Office of  
Environment  
& Heritage

DOC19/32912  
SSD 8800

**Parramatta Leagues Club Hotel (SSD 8800) – 1 Eels Place, Parramatta - Environmental Impact Statement**

### Leagues Club Hotel (SSD 8800) – 1 Eels Place, Parramatta - Environmental Impact Statement

DRAWING TITLE
GA FLOOR PLAN - LEVEL 04 - HOTEL & GARDEN TERRACE

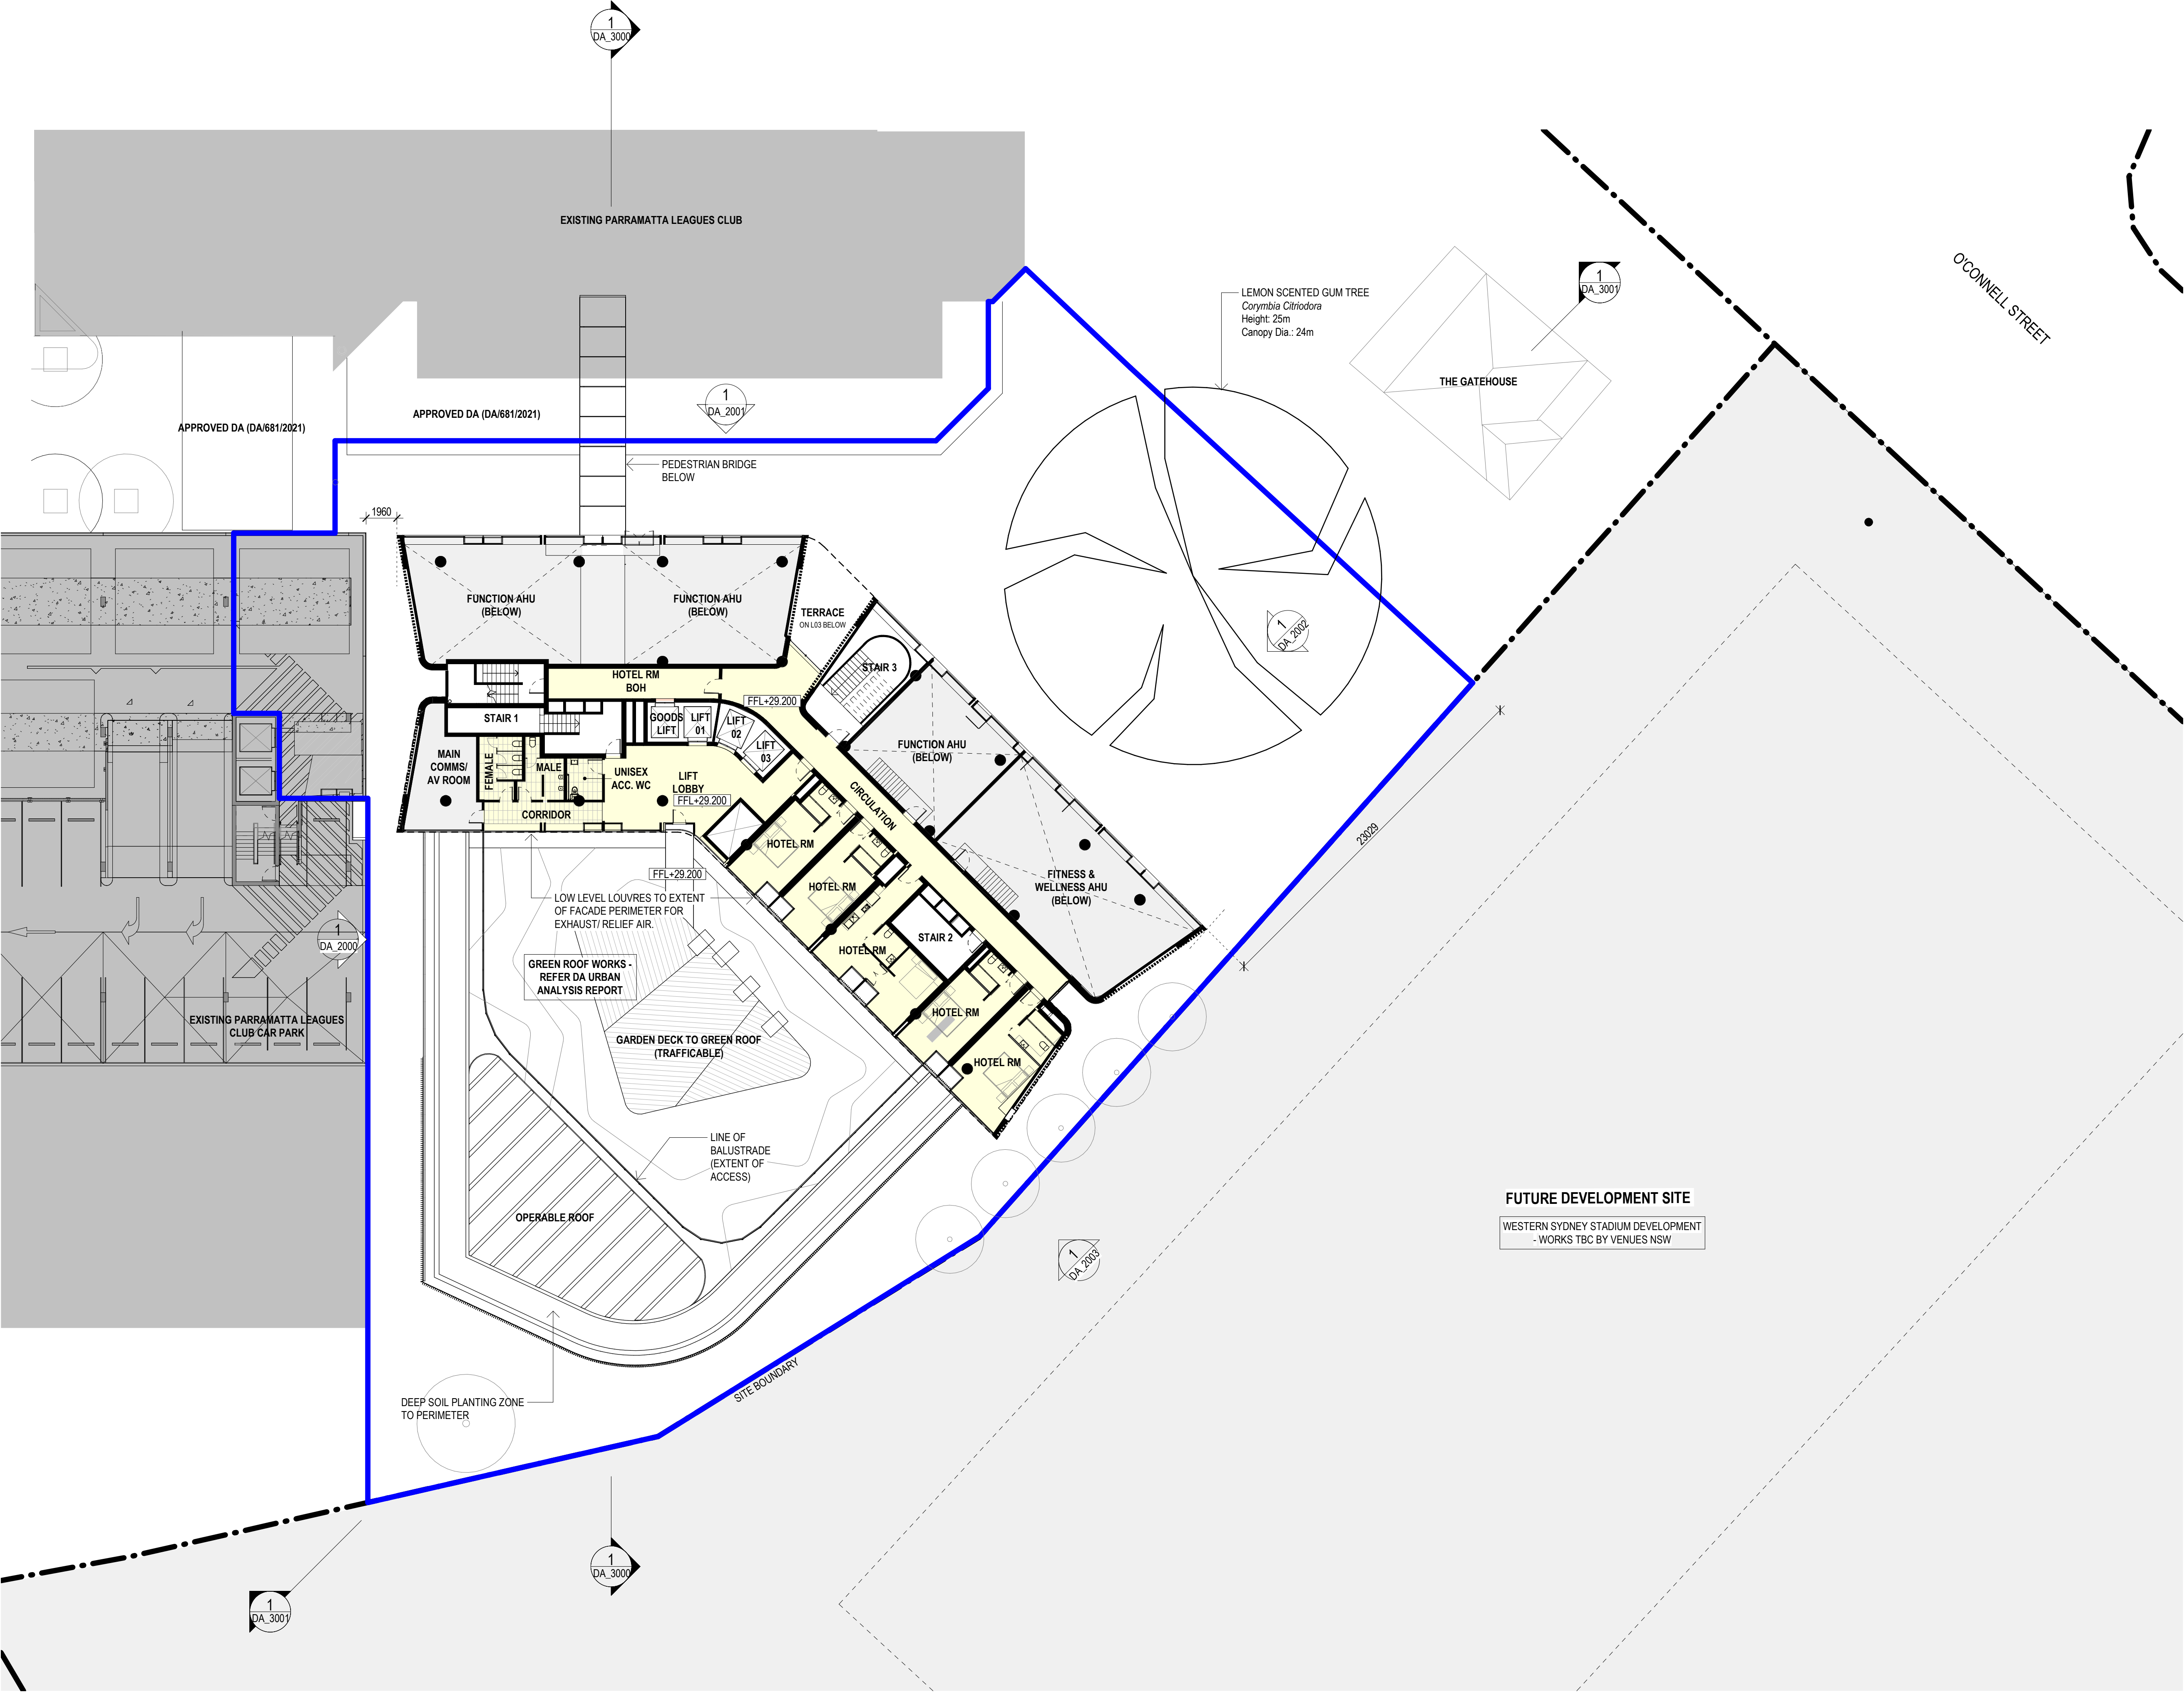
The ESD report recommends green roofs and green walls are considered for the development (page 9) and the Public Domain and Landscape report shows a lawn area and planting is proposed on level 4 and a grassed area with vegetation and small tree planting is proposed on the open roof on level 16 (see pages 39-40). OEH supports the inclusion of green roofs into the design and recommends that if the project is approved a condition of approval is included for the proposal to include green roofs and green walls into the design. The benefits of Green Roofs and green walls are outlined in the OEH (2015) Urban Green Cover in NSW Technical Guidelines which can be found at the following link:

- 1) The proposal shall incorporate green roofs and green walls into the design.

DRAWING TITLE
GA FLOOR PLAN - LEVEL 14 - HOTEL & ROOF TERRACE BAR

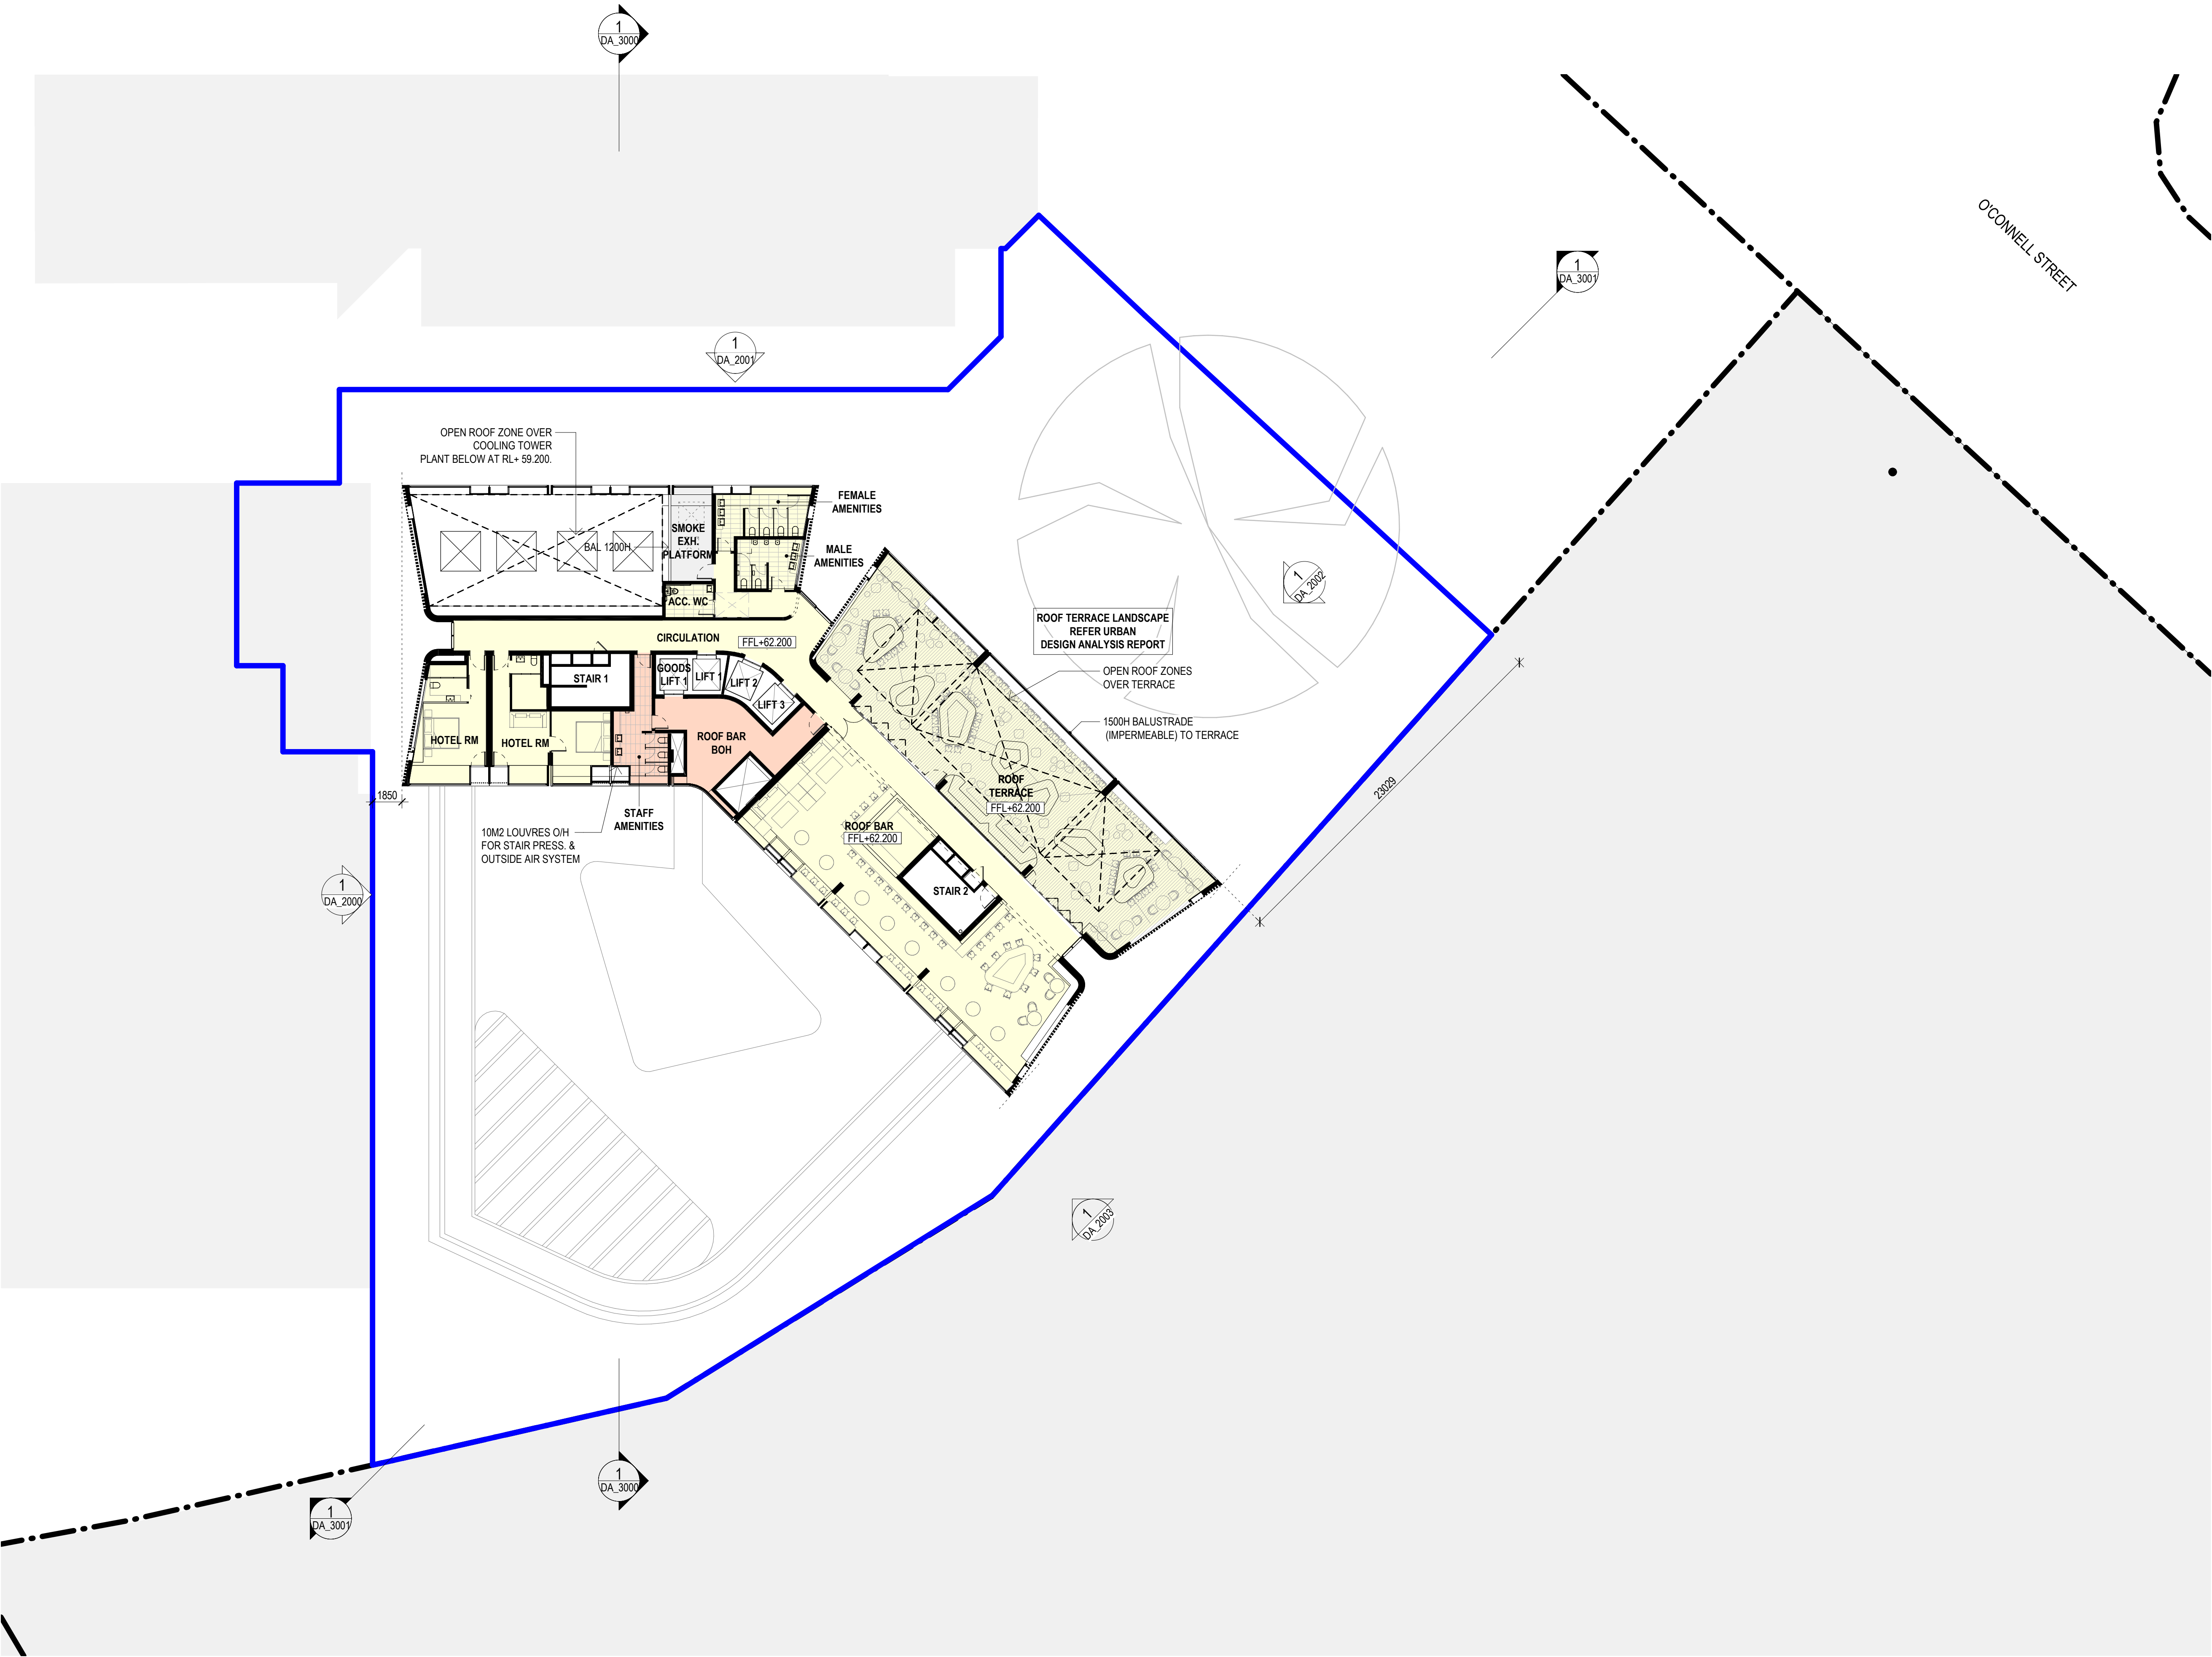
- The assessment of impacts in the BDAR does not include a discussion of impacts on the Grey-headed Flying-fox (GHFF) that may occur at the operational stage, such as noise impacts from the proposed rooftop bar, terrace and function room

- continues for 24 months post construction during the operational phase of the development to assess the potential impacts such as noise from the rooftop bar.
